Recommendation Report for Planning Permission for Works or Extension to a Dwelling

REF NO: FG/138/18/HH

LOCATION: 80 Langbury Lane
Ferring
BN12 6QE

PROPOSAL: Single storey rear extension.

REAR EXTENSION

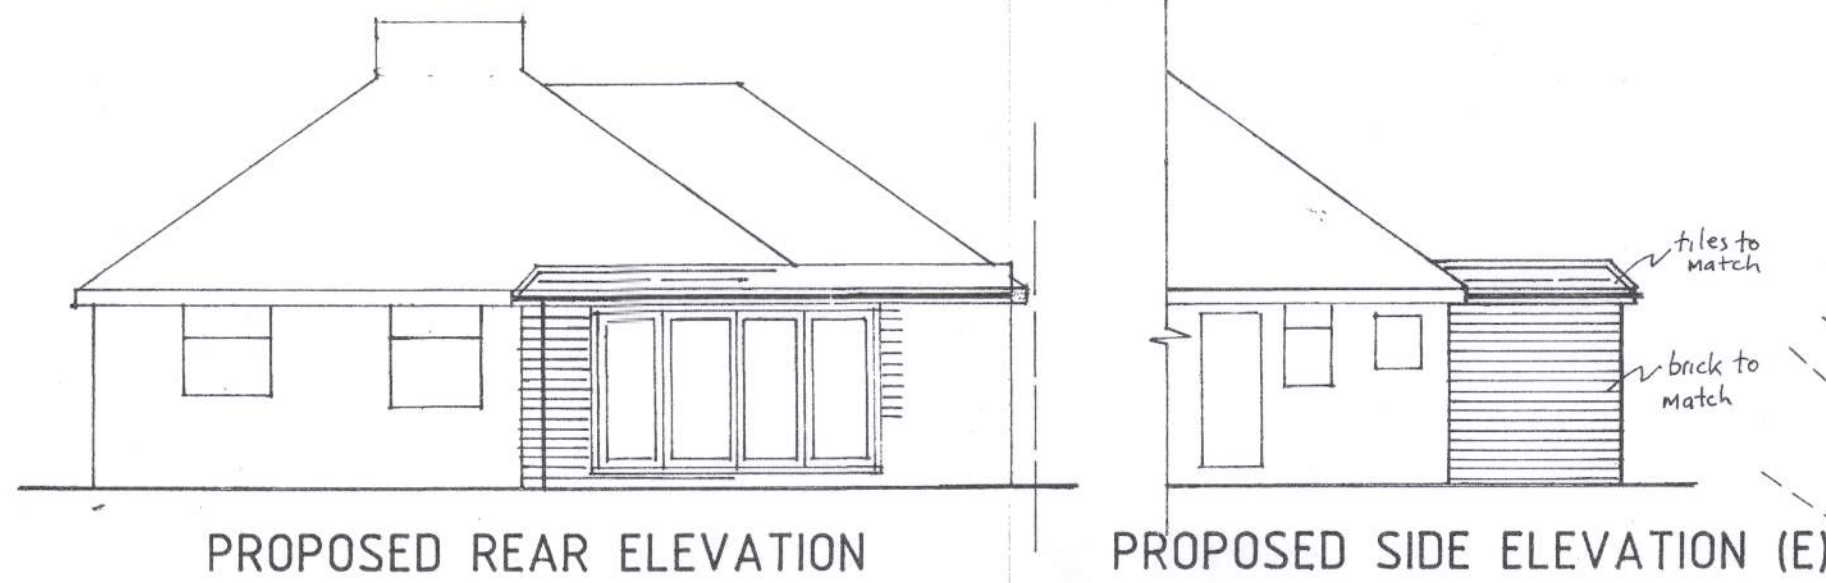
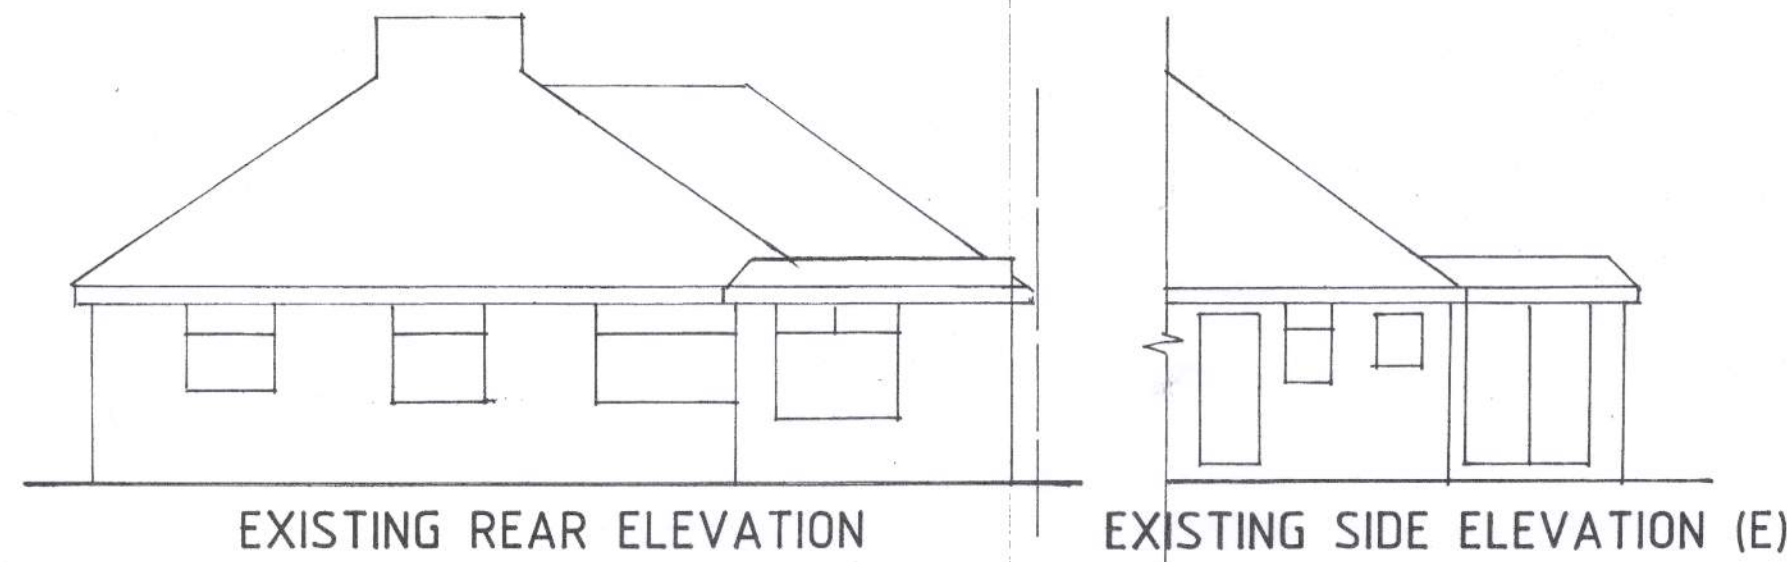
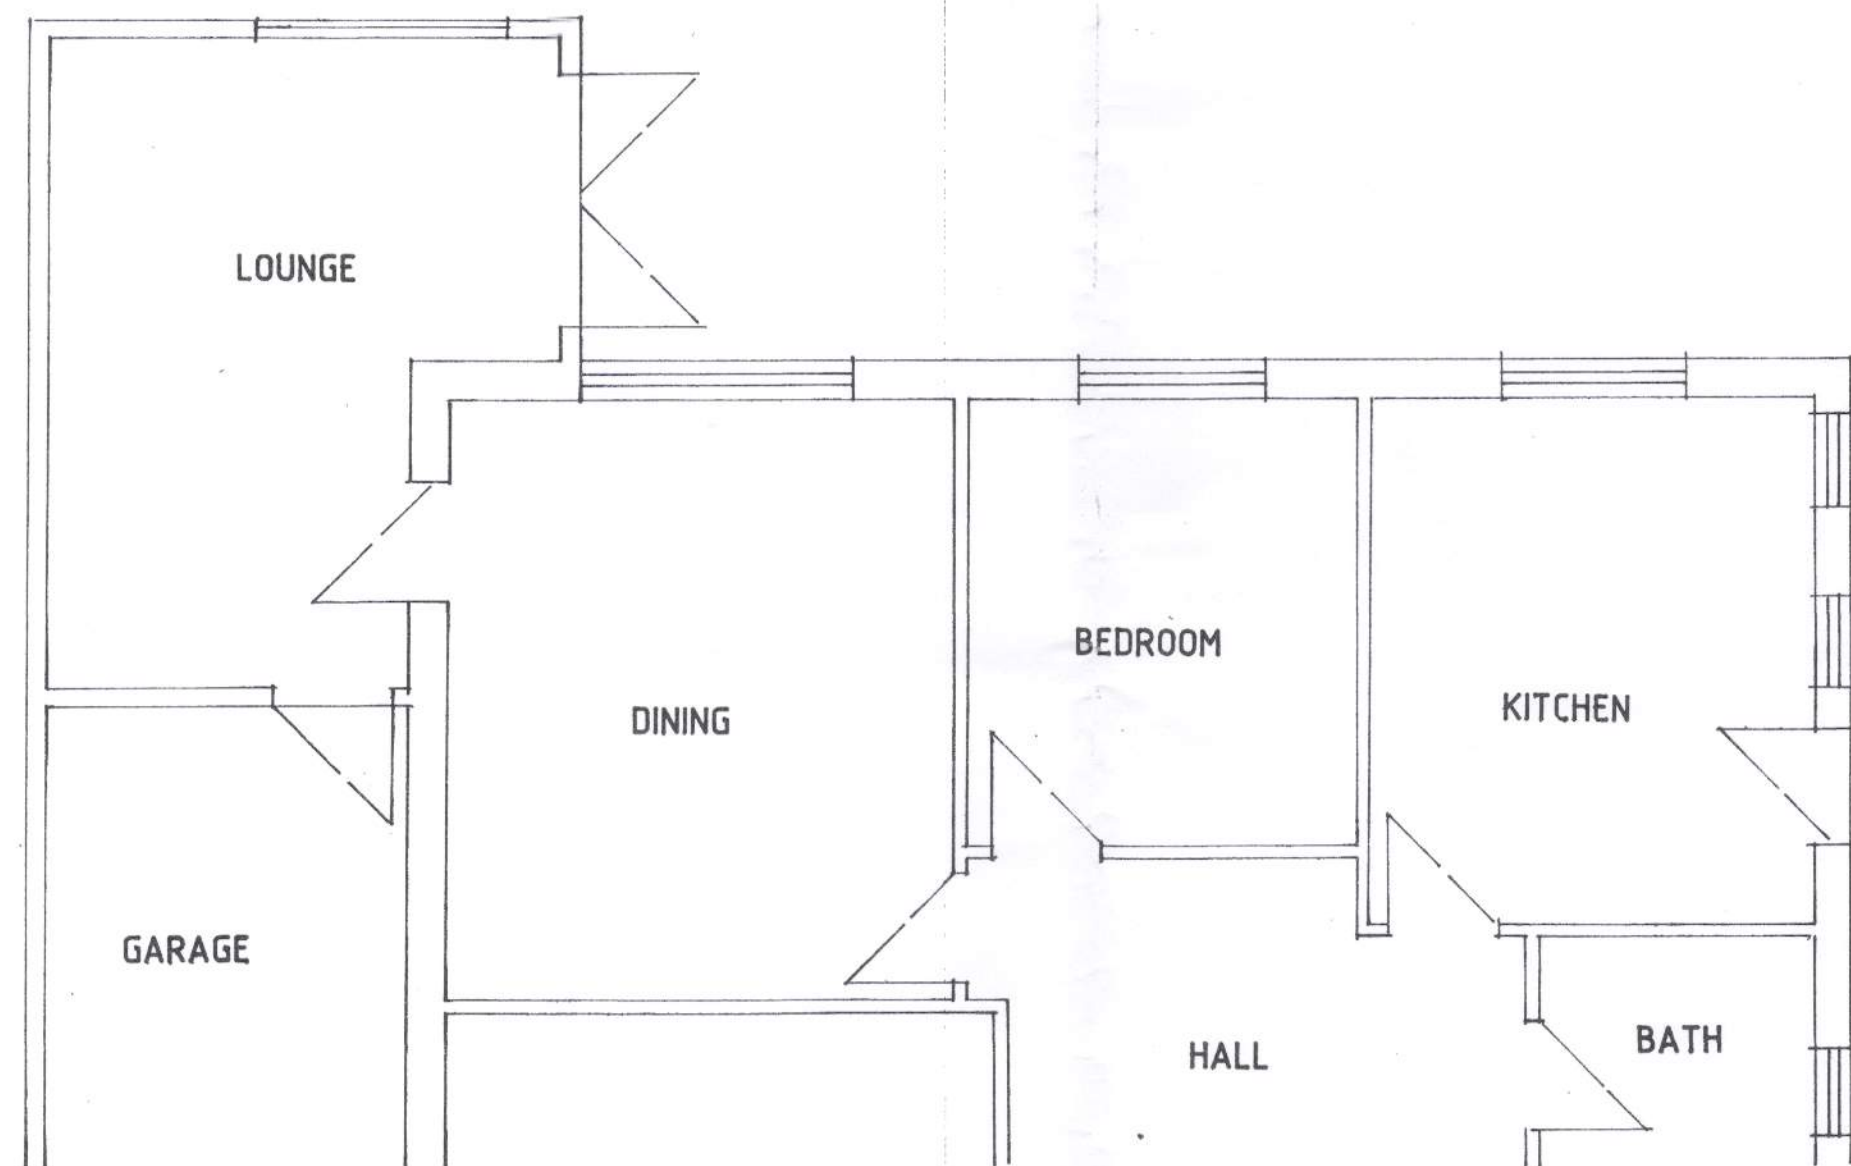
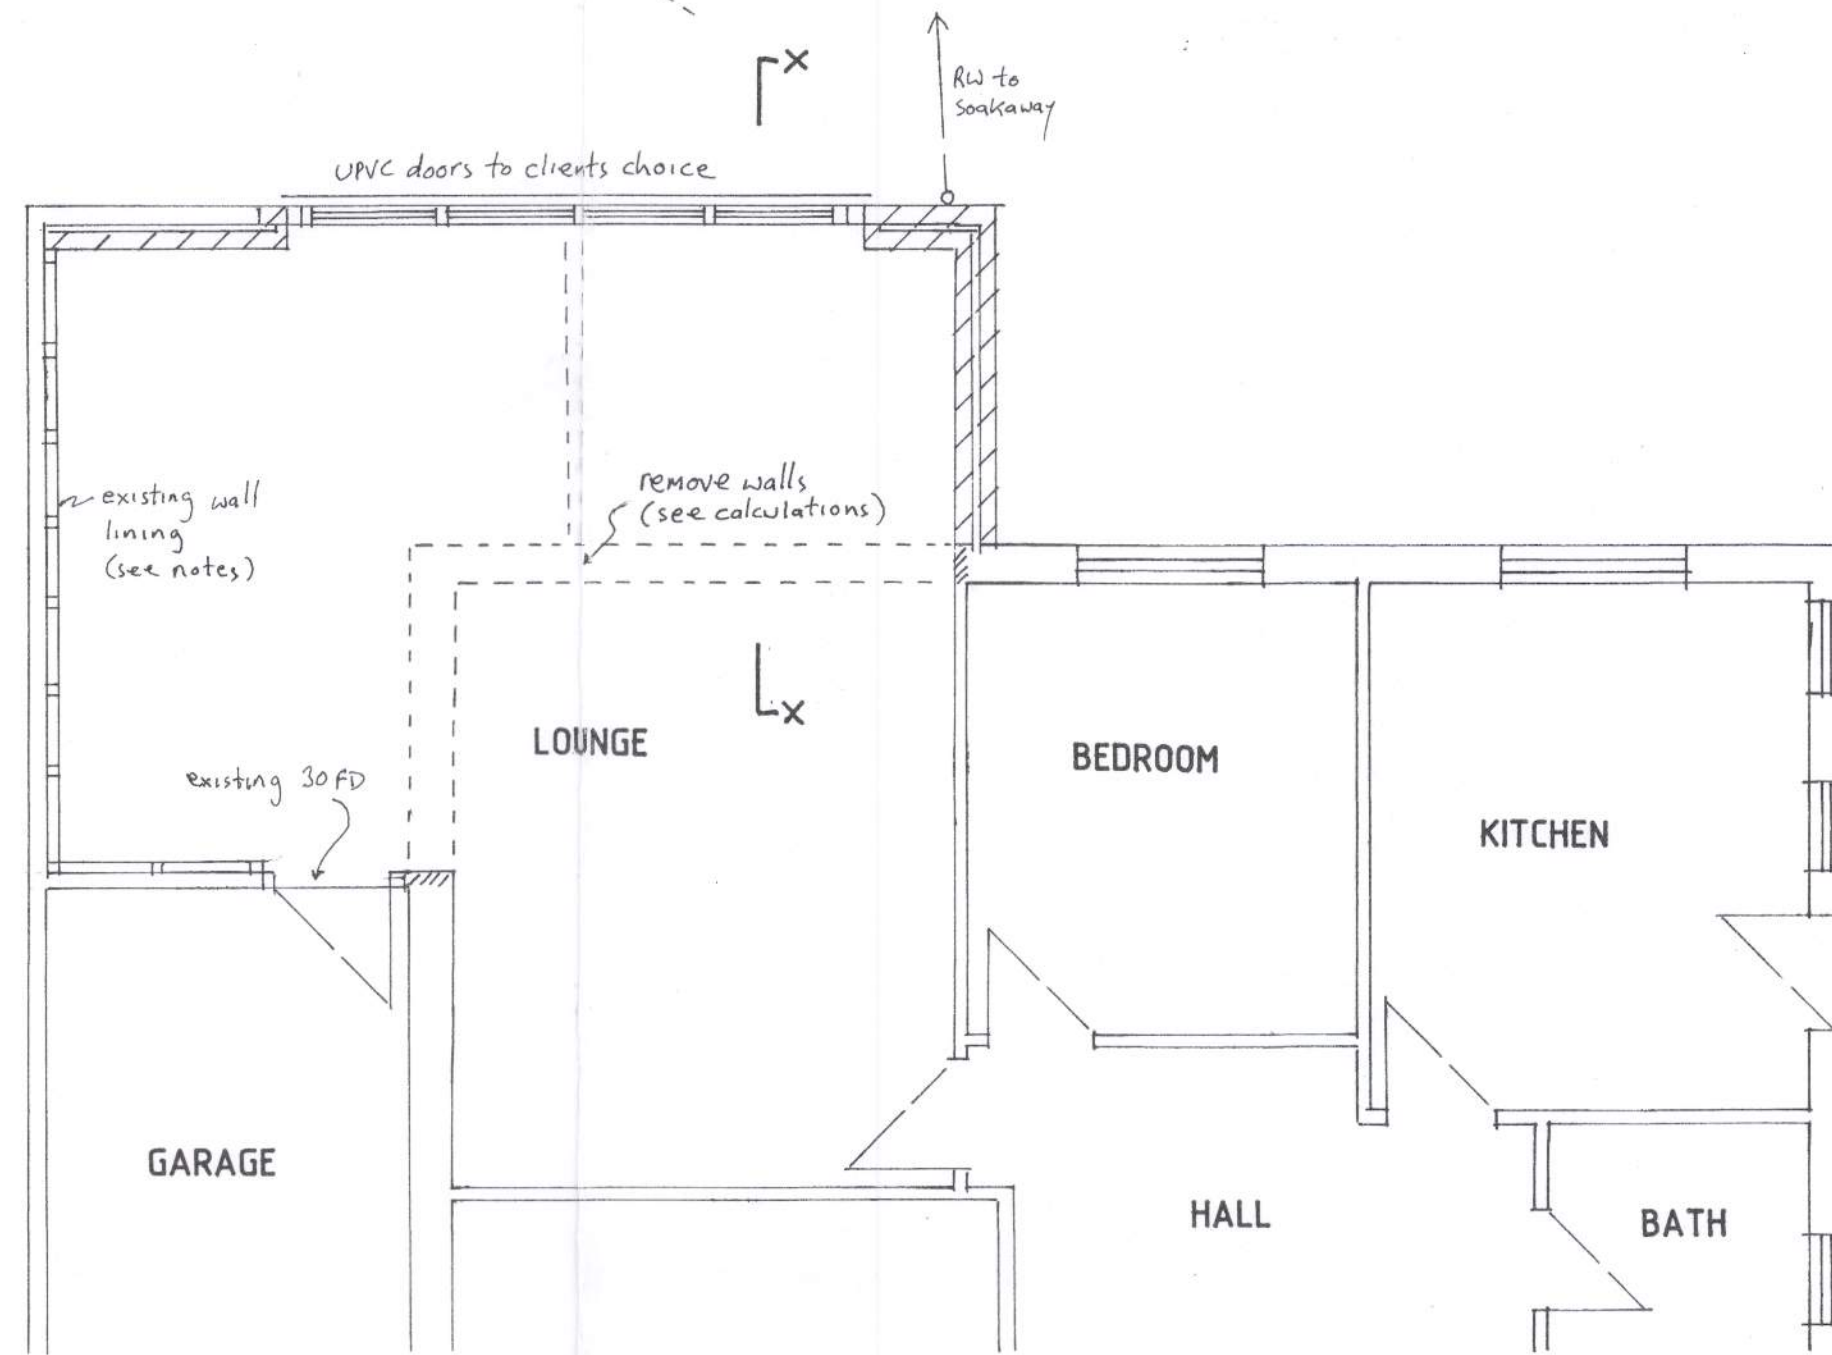
The maximum height of the proposed development is 3m from ground level, which matches the existing rear projection. This is approximately 3.15m lower than the existing ridge height of the host dwelling. Therefore, the proposed development is considered to appear subservient to the host dwelling and it is not considered to harm its established character.

The proposals maximum height is 3m, which is set over 5m from the Eastern boundary of the site. Resultant of this separation distance, there is not deemed to be any significant adverse impact on neighbouring residential amenity as a result of the development. There is not considered to be a significant loss of privacy as a result of this development, as the proposal features no windows on its Eastern elevation, and even if there were, any views would be impeded by the fencing that lies between the two properties.
